Lime Down

Solar Park

Statement of Common Ground with Cotswolds National Landscape Board (Tracked)

Document Reference: EXAM/8.7

LIME DOWN SOLAR PARK
Figure 3-4-1
Lime Down Solar Park - Site A
Landscape and Ecology Mitigation Plan - Revision 3
END10168/APP/6.2
5(2)(a)

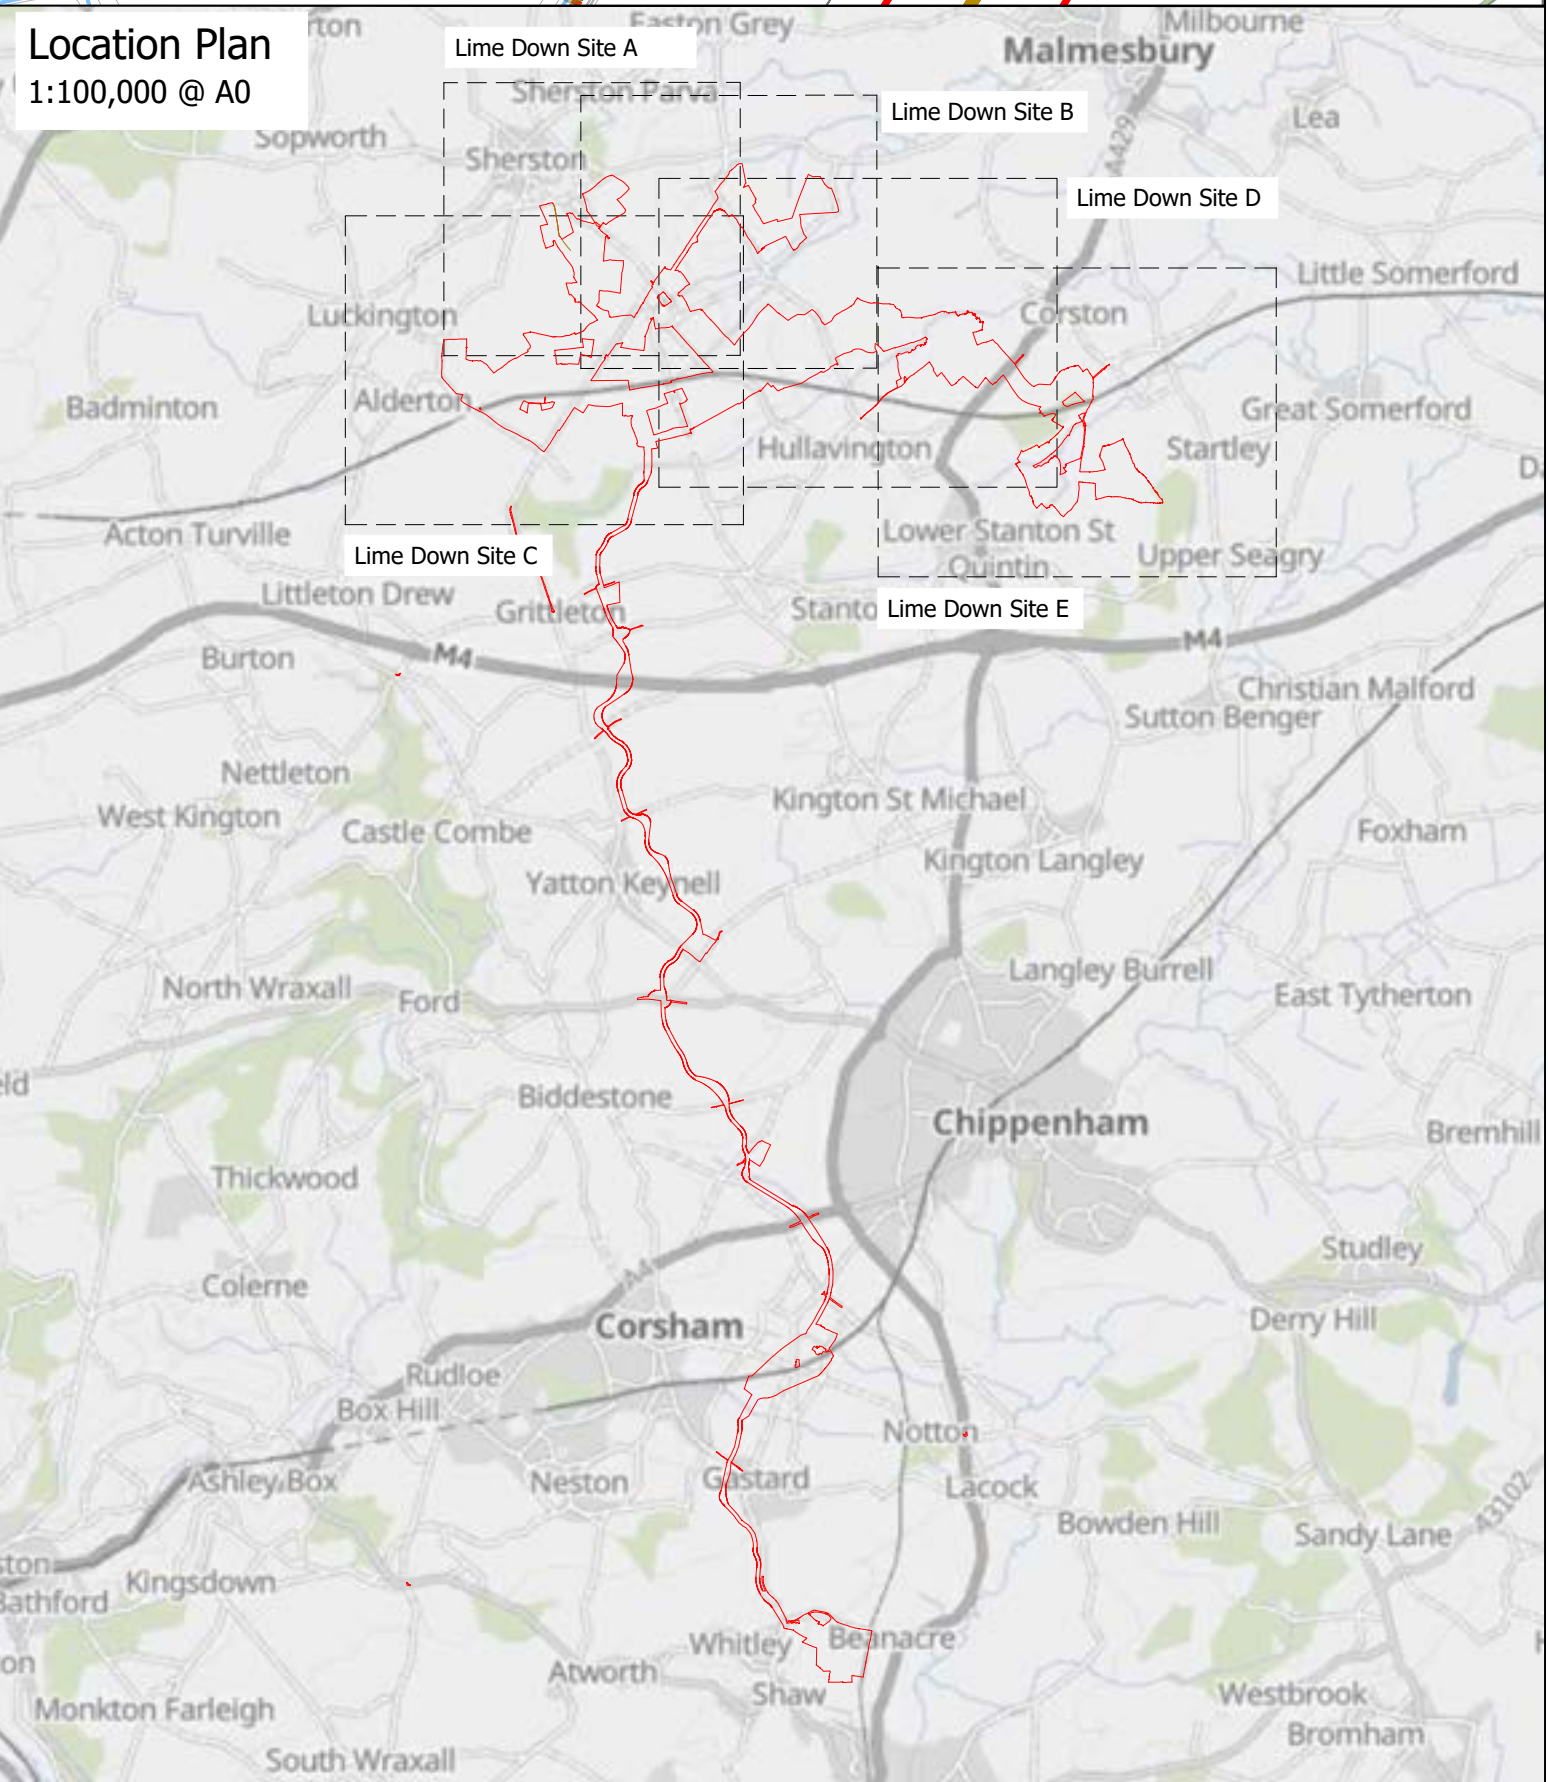
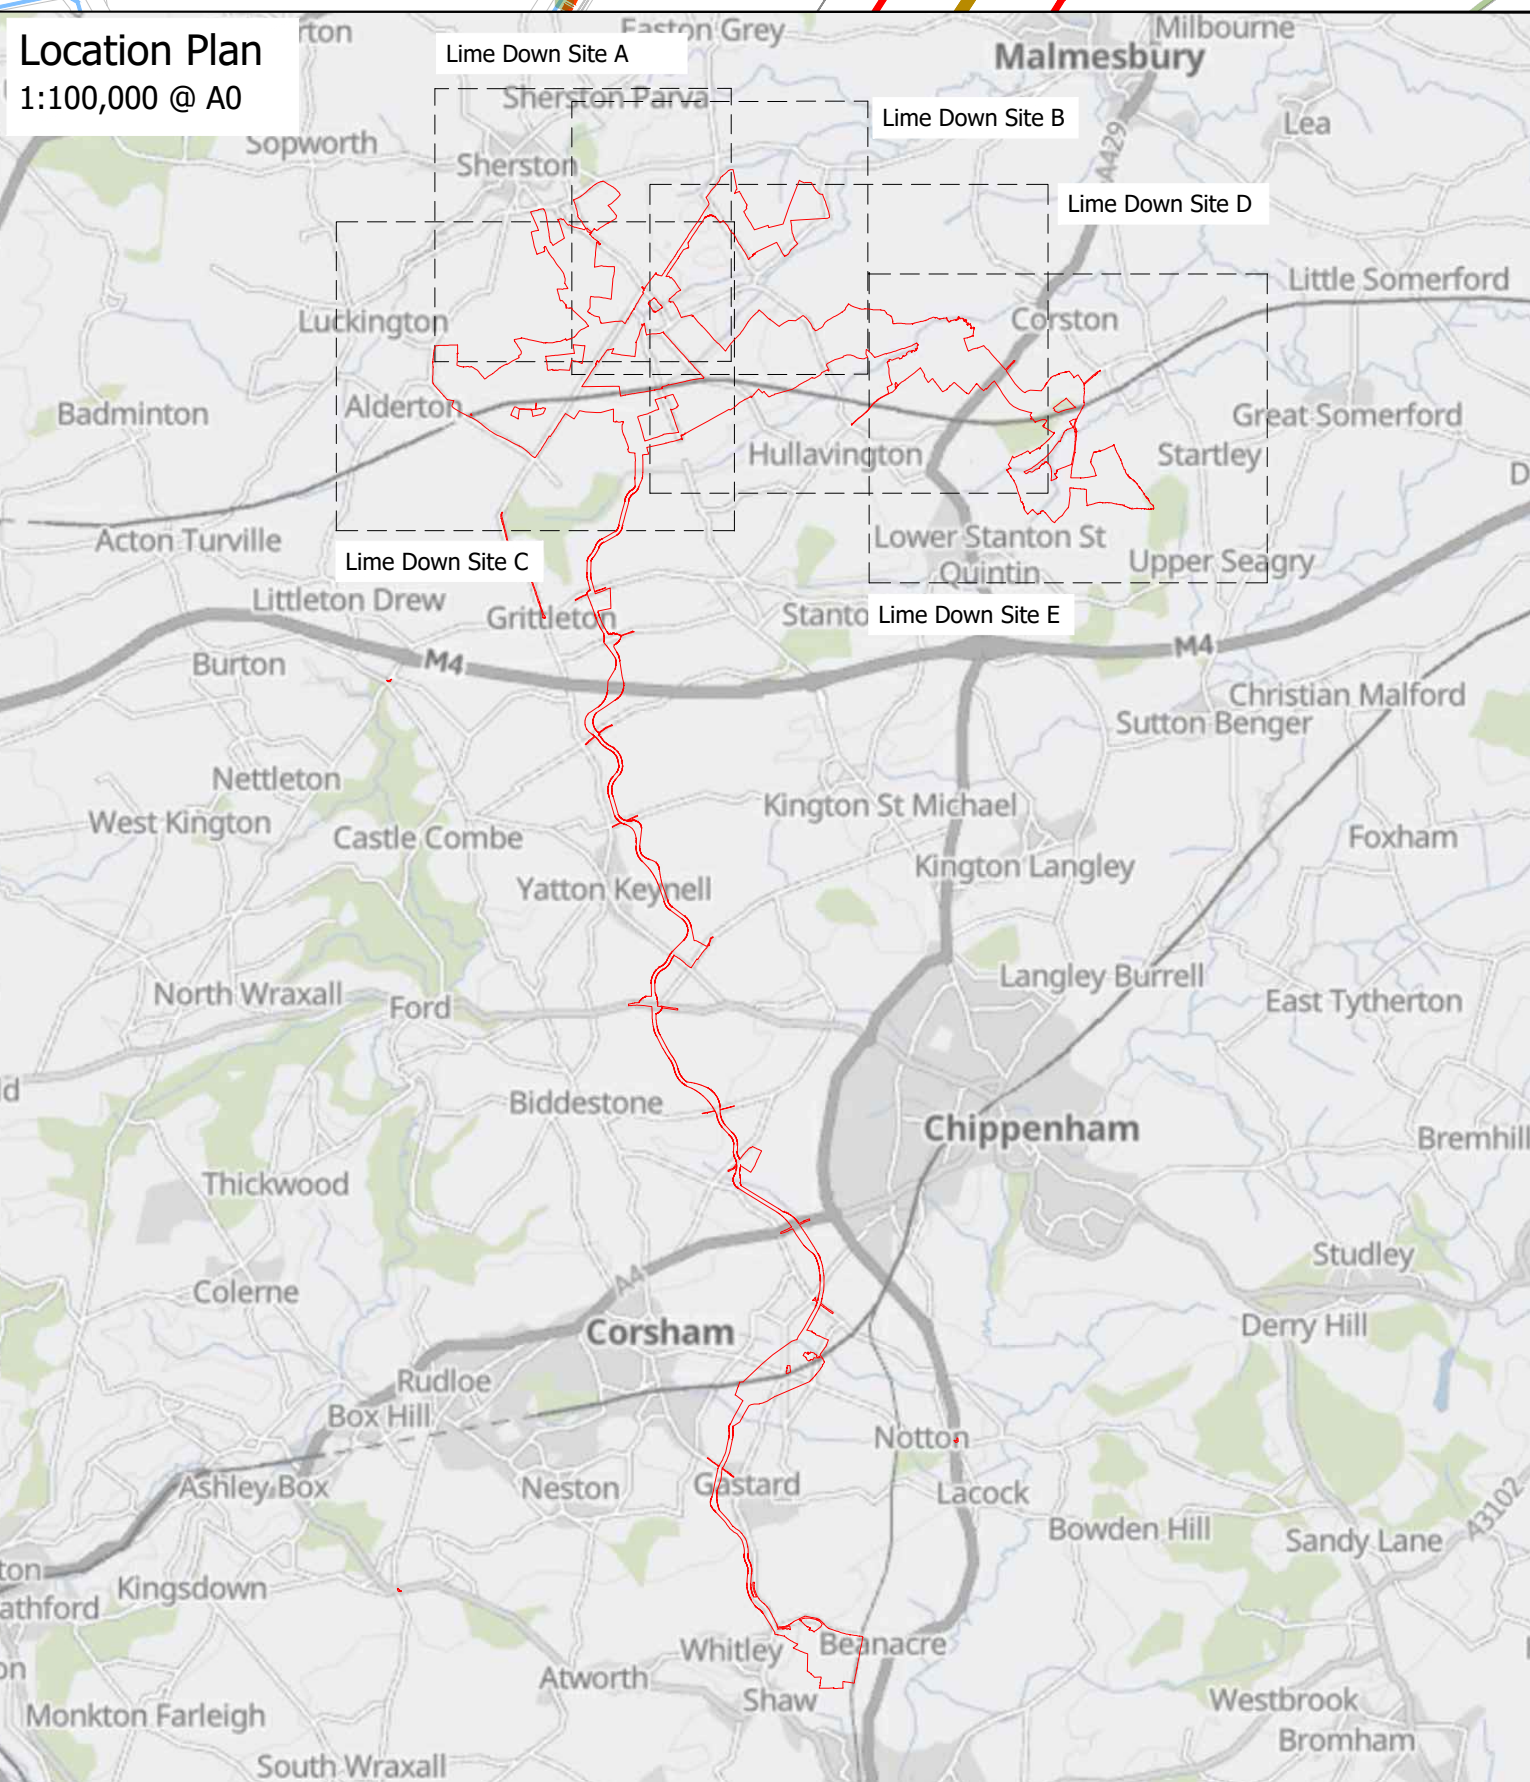
3.1.14	Outline Landscape and Ecological Management Plan (PMIE 7)	The CNLB confirm their general support for the aims, scope and content of the OLEMP. However, acknowledging that the site is located within the CNL's setting, the board has several specific recommendations for the Outline Landscape and Ecological Management Plan (OLEMP, APP-283) which can be addressed through subsequent submission of the Detailed Landscape and Ecological Mitigation Plan.	The landscape and ecological improvements are set out in the ES Volume 2, Figure 3-4-1 to 3-4-5.2: Landscape and Ecology Mitigation Plans [REP1-029 to REP1-032] . The Outline LEMP [APP 283] are considered acceptable. Following further development of the Scheme, more detailed planting plans including detail of areas of landscape mitigation, location and types of planting (species), as well as number, density and specification will be provided prior to any works commencing. The detailed landscape proposals will consist of the area and extent of the Scheme shown on ES Volume 2, Figure 3-4-1 to 3-4-5.2:	Under Discussion Agreed

Reference	Sub-topic	CNLB Position	Applicant's Position	Status
3.1.17	Removal of Solar PV Panels in the southern part of Field A1, the remainder of Field C6 and Fields C7 and C9 (PMIE 6).	CNLB support the decision to remove Solar PV Panels in the southern part of Field A1, the remainder of Field C6 and Fields C7. CNLB note that Field C9 remains unchanged from the design shown at statutory consultation (see PMIE 6).	The final iteration of the Scheme includes the avoidance of panels in the southern<u>northern</u> part of Field A1, the remainder of Field C6 and Fields C7, C1, C6, C8, and C9. These areas are identified for habitat enhancement. Following a meeting with an officer from the CNL Board on 30th March 2026, <u>Updated position</u> It was confirmed <u>in the meeting on 13 July 2026</u> that this relates to PMIE 3. <u>Discussions are ongoing surrounding following the removal of panels in Field C9 and the results of the further assessment of C7 which demonstrated that the potential visibility of panels would be extremely limited at worst.</u> <u>It was confirmed in the meeting on the 12 August 2026 that the southern half of field A1 would also be removed from the Scheme.</u> <u>PMIE 6 was confirmed to be resolved.</u>	<u>Under Discussion</u> <u>Agreed</u>

Reference	Sub-topic	CNLB Position	Applicant's Position	Status
			Landscape and Ecology Mitigation Plans [REP1-029 to REP1-032]. The Outline LEMP [APP 283] is secured by Requirement 7 of Schedule 2 of Draft DCO [REP1-007]. Following a meeting with the CNL on 30th March 2026, it was agreed that recommendations to the Outline LEMP [APP 283] can be addressed through the subsequent submission of the detailed Landscape and Ecological Management Plan post consent as secured by Requirement 7 of Schedule 2 of Draft DCO [APP 016]. Detailed versions of the Outline LEMP [APP 283] will be prepared in consultation with stakeholders, with express reference to the CNL Board as a stakeholder for aspects of the Outline LEMP [APP 283] relevant to the CNL and its setting. <u>Updated Position</u> <u>PMIE 7 was discussed in a meeting between the Applicant and the CLNB</u>

Reference	Sub-topic	CNLB Position	Applicant's Position	Status
			on the 13 July 2026. It was confirmed that the matter is now resolved and can be moved to Agreed.

Reference	Sub-topic	CNLB Position	Applicant's Position	Status
			<u>which demonstrated that the potential visibility of panels would be extremely limited at worst.</u> <u>It was confirmed in the meeting on the 12 August 2026 that the southern half of field A1 would also be removed from the Scheme.</u> <u>PMIE 6 was confirmed to be resolved.</u>

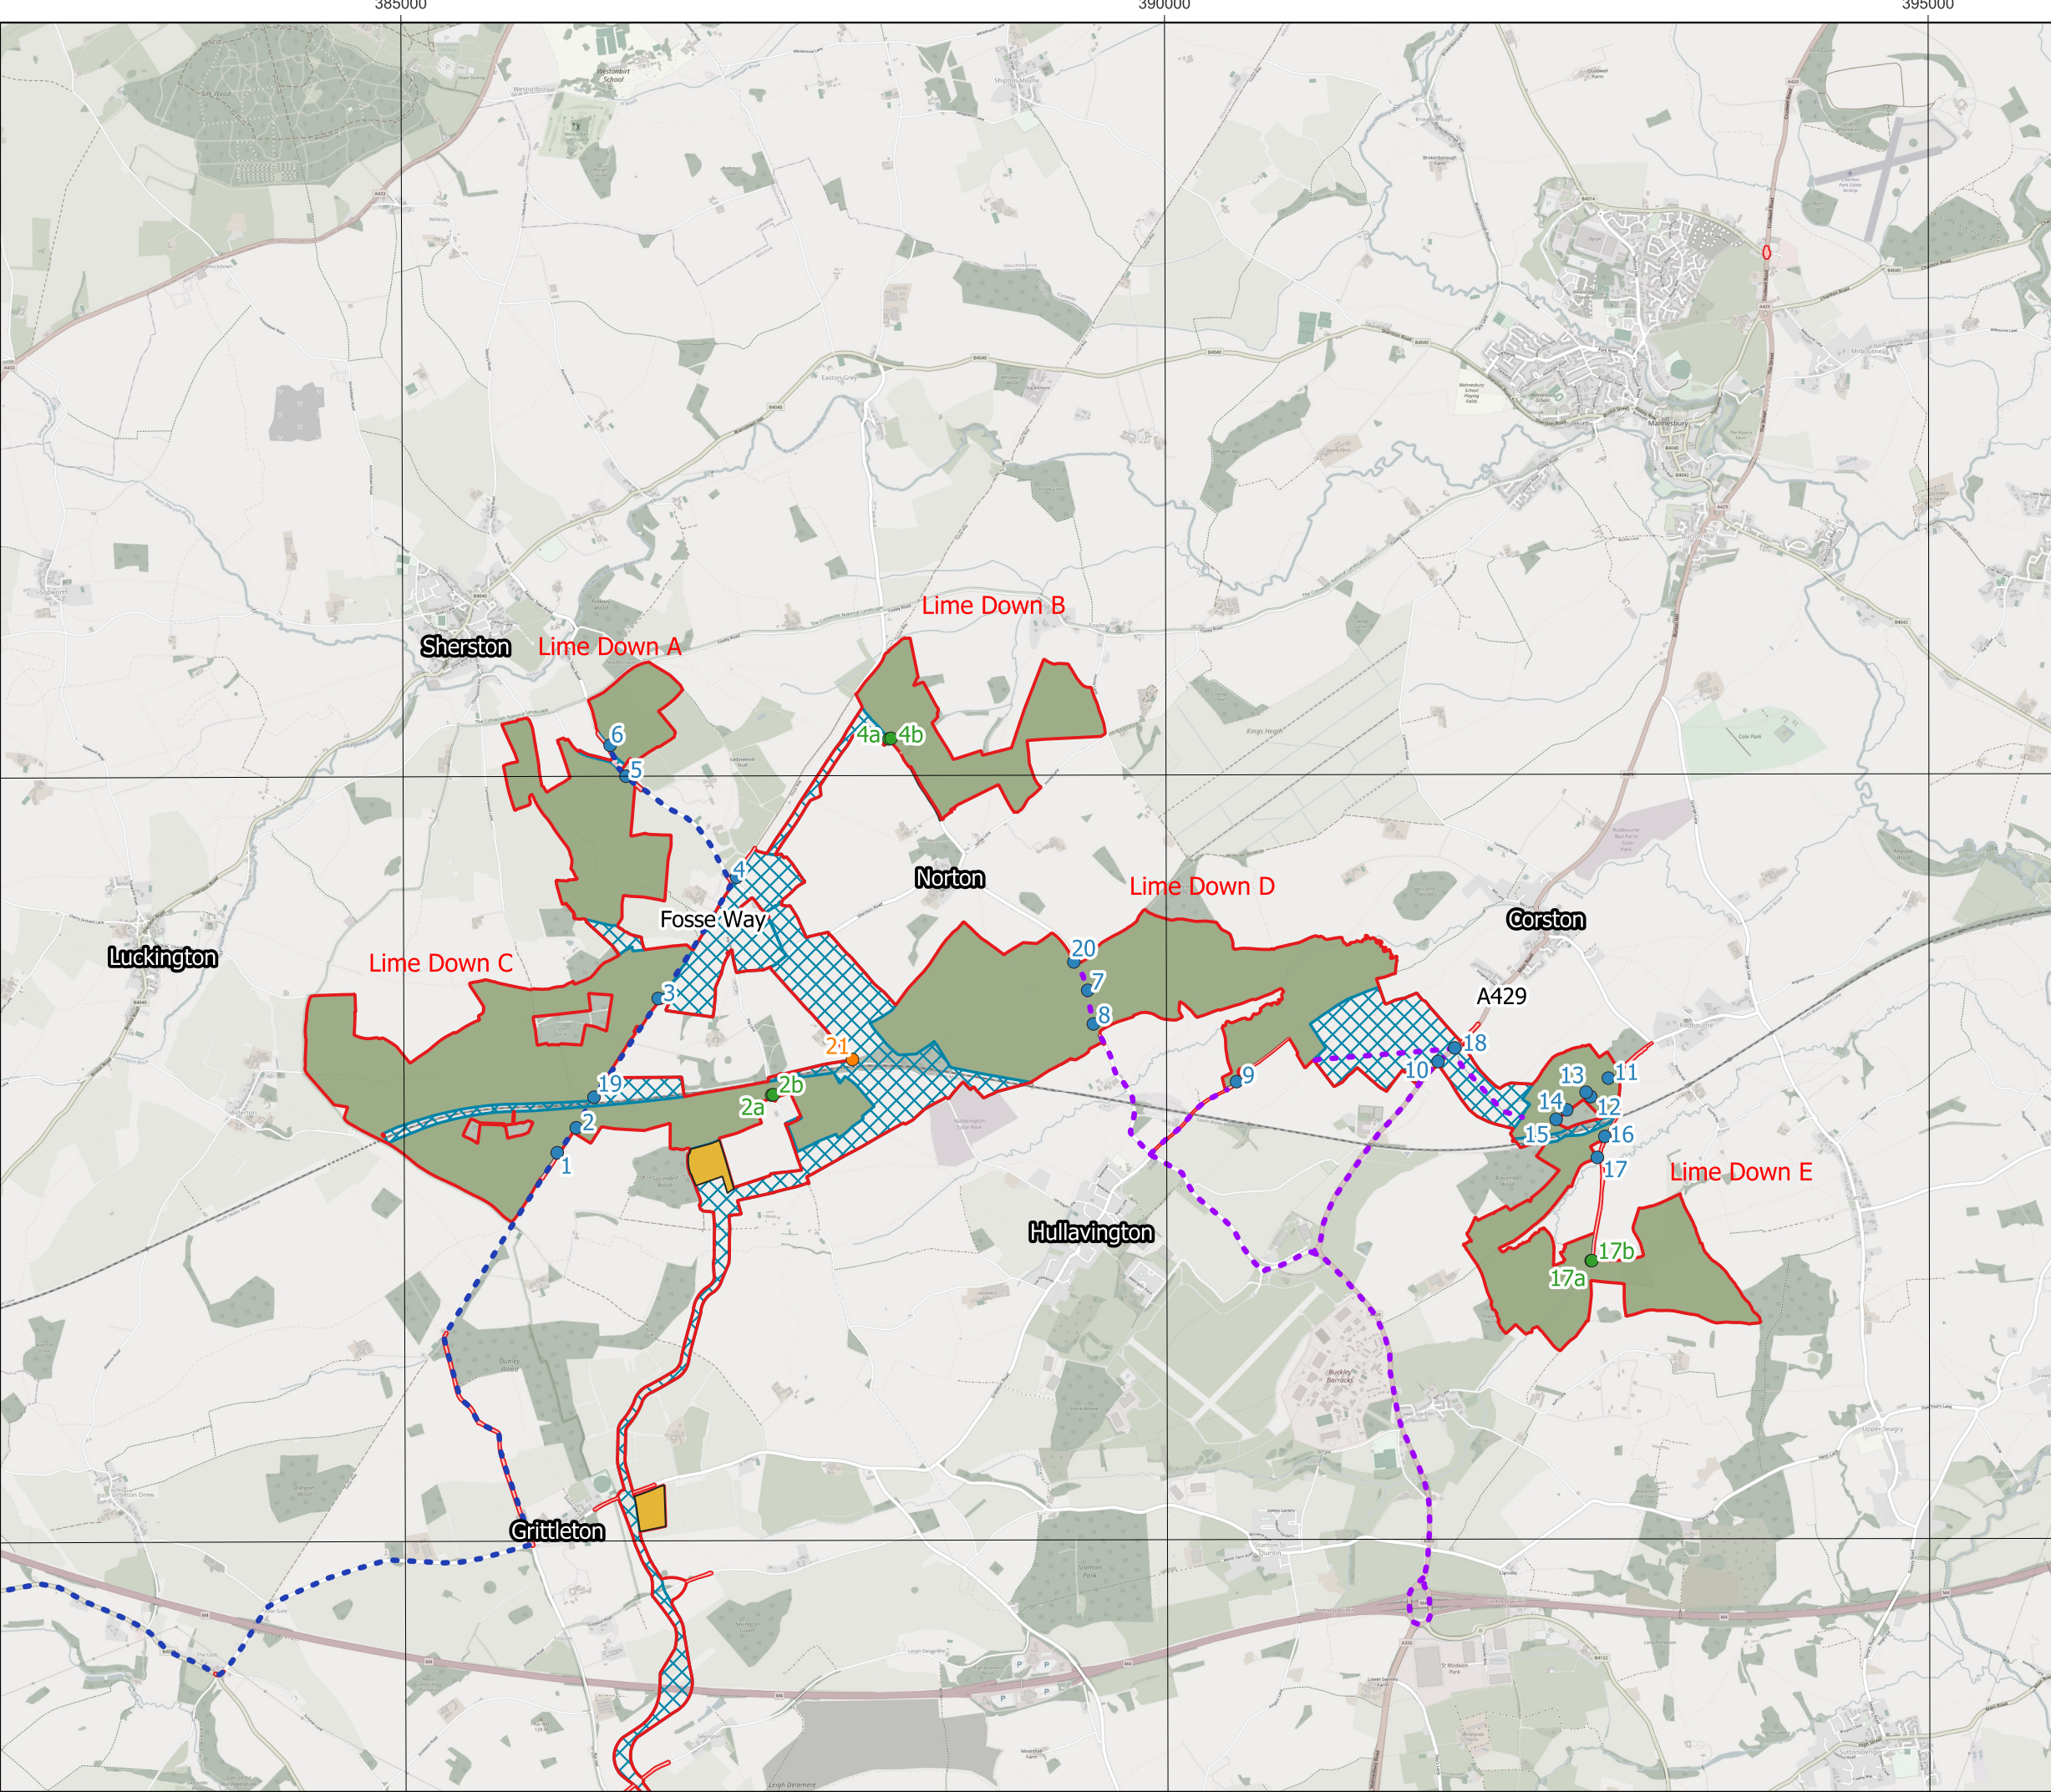
Reference	Sub-topic	CNLB Position	Applicant's Position	Status
		movements on roads along the CNL boundary as well as to traffic movements on roads within the CNL. Figure 13.1 of the ES shows a proposed construction traffic route to serve Sites A, B and C which runs from M4 J18 through the CNL along the A46, B4040, B4039, an unnamed road east to Grittleton and then the Alderton Road and Fosse Way, leaving the CNL at the crossroads with Fosse Lodge. The route then continues outside of the CNL up the Fosse Way. Table 13-24 identifies that overall traffic flows along the B4040, the unnamed road west of Grittleton, Alderton Road and Fosse Way all within the CNL would exceed the 10% threshold in terms of total traffic. Increases in HGV flows along these roads would also exceed the 10% threshold along these routes as well as along the B4039. HGV flows would increase by between 68.5% and 250% on these routes
